PLANNING AMENDME NT

APPLICANT NAME AND ADDRESS MR & MRS S GILBY 7 BARBERS DRIVE SOUTH CROWLAND Lincs PE6 0EY Telephone:	AGENT NAME AND ADDRESS JULIAN WARRICK 8 BEECH GROVE EDNINGTON Lincs DN11 4XQ. Telephone: 01775 820123
SITE ADDRESS DETAILS AS APPLICANT ADDRESS	
CURRENT APPLICATION NO: This amendment cannot be considered unless the relevant reference is stated.	H02-0760-20
Building Regulation reference relating to same development (if applicable)

FULL DESCRIPTION OF DEVELOPMENT OF CURRENT APPLICATION THAT THIS AMENDMENT RELATES TO	PROPOSED 2 STOREY EXTENSION & ALTERATIONS INC. DETACHED GARAGE.
--	---

J136-PL 1A

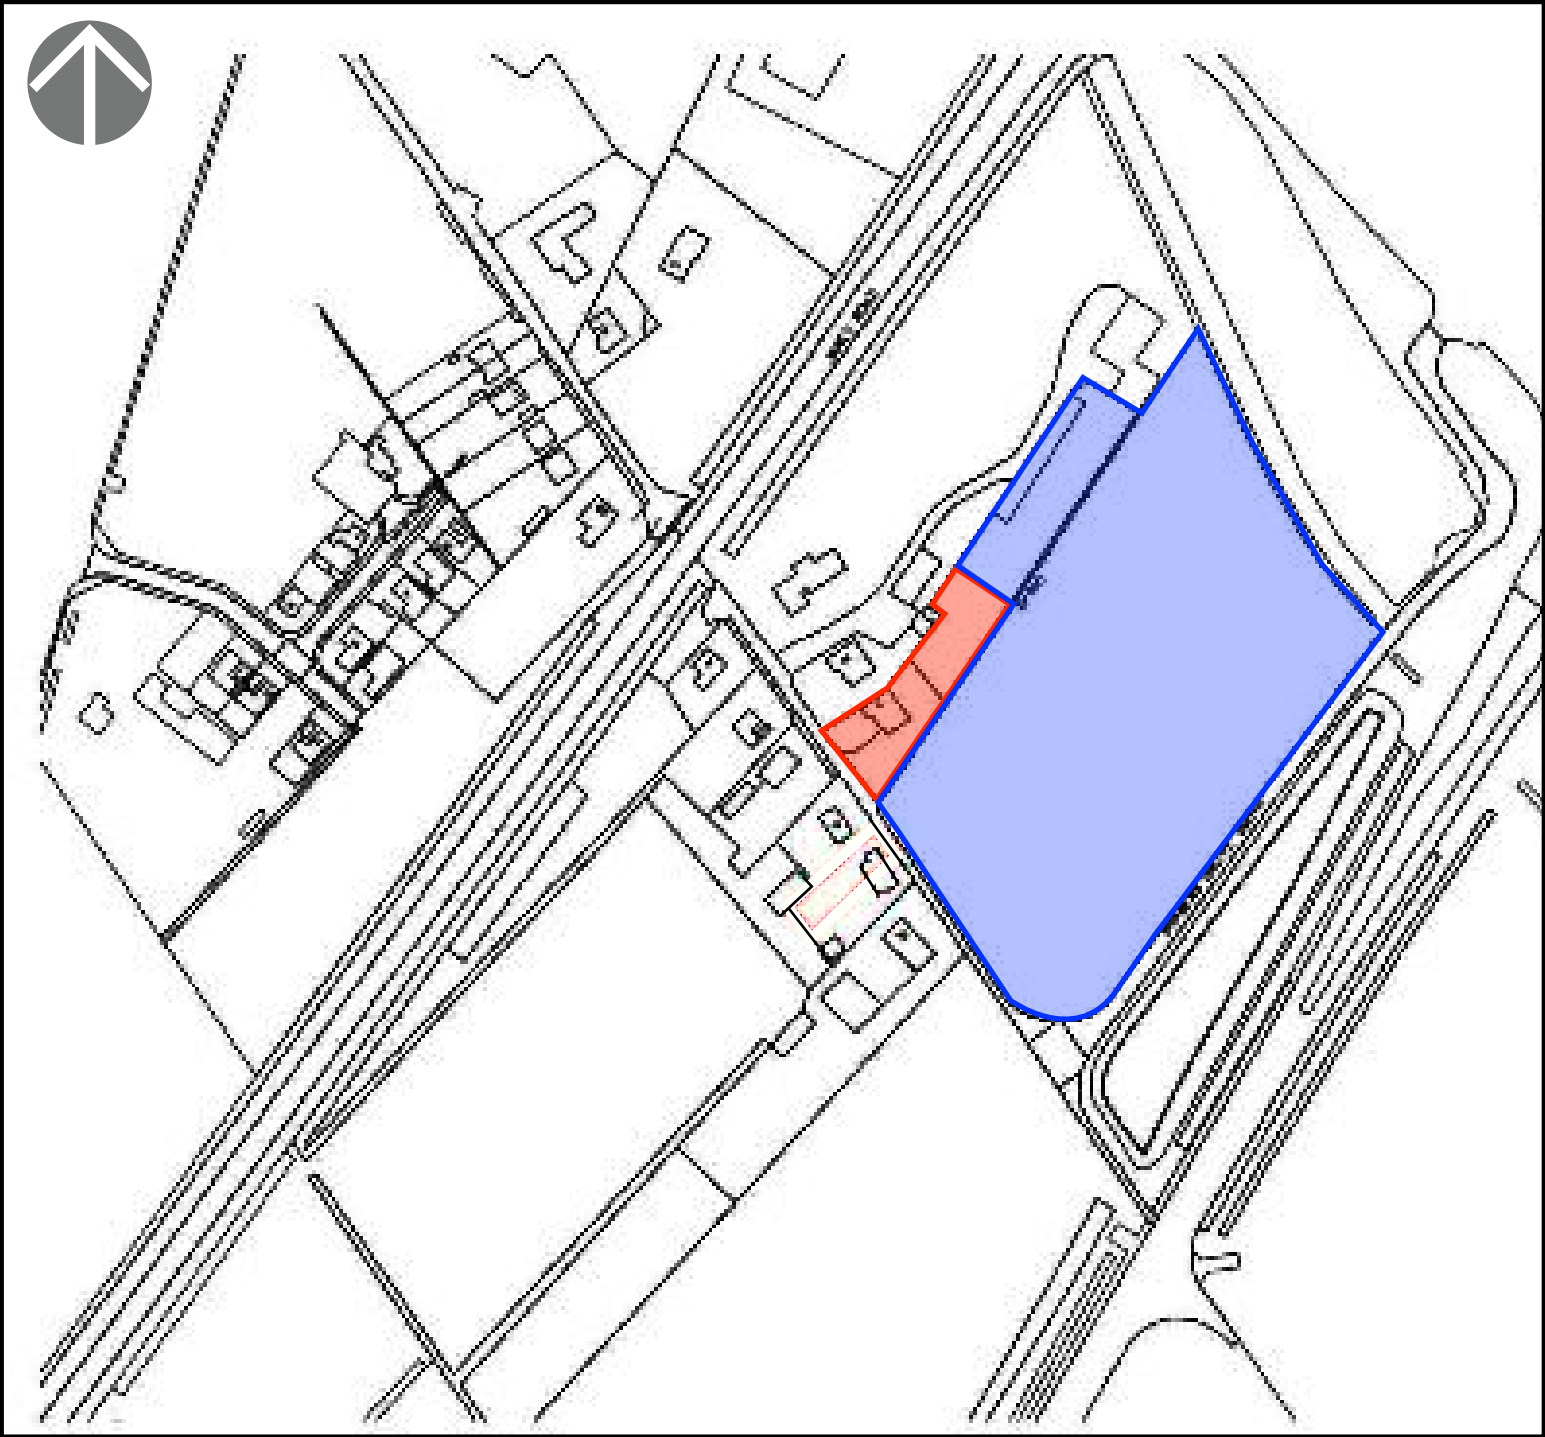
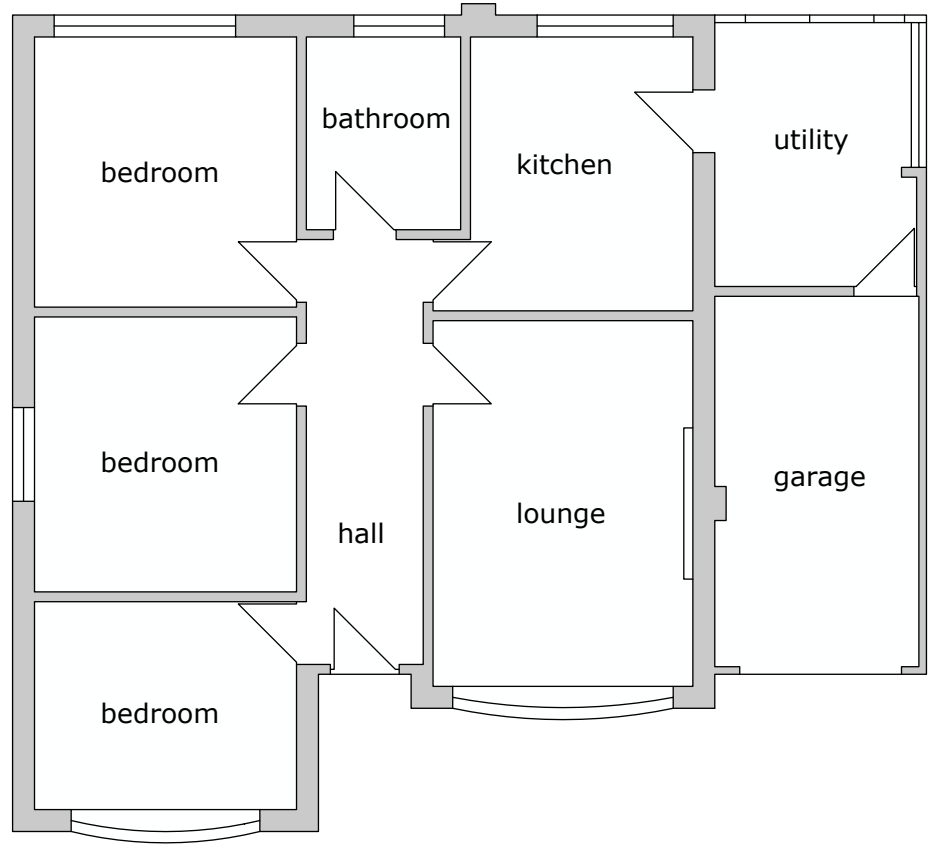
State details of amendments proposed. (Give a full detailed list of the changes, and also mark these clearly on the accompanying plans. Only the changes listed here will be considered)	ADDITIONAL DIMENSIONS ADDED TO GARAGE ON SITE PLAN & HEIGHT SHOWN TO EXTENSION.	
State drawing numbers of the current submission	Jr36 - PL 1, 2 & 3.	
Has this amendment been requested by the Council? (If so, state Officer dealing with the application)	YES/ NO	MARIA SALEMME.
Describe any part of the original development which is excluded by virtue of the amendment, and state any alteration to plot numbers		
Has a similar amendment been submitted under Building Regulations? (If so, state Building Control Surveyor dealing with application)	YES/ NO
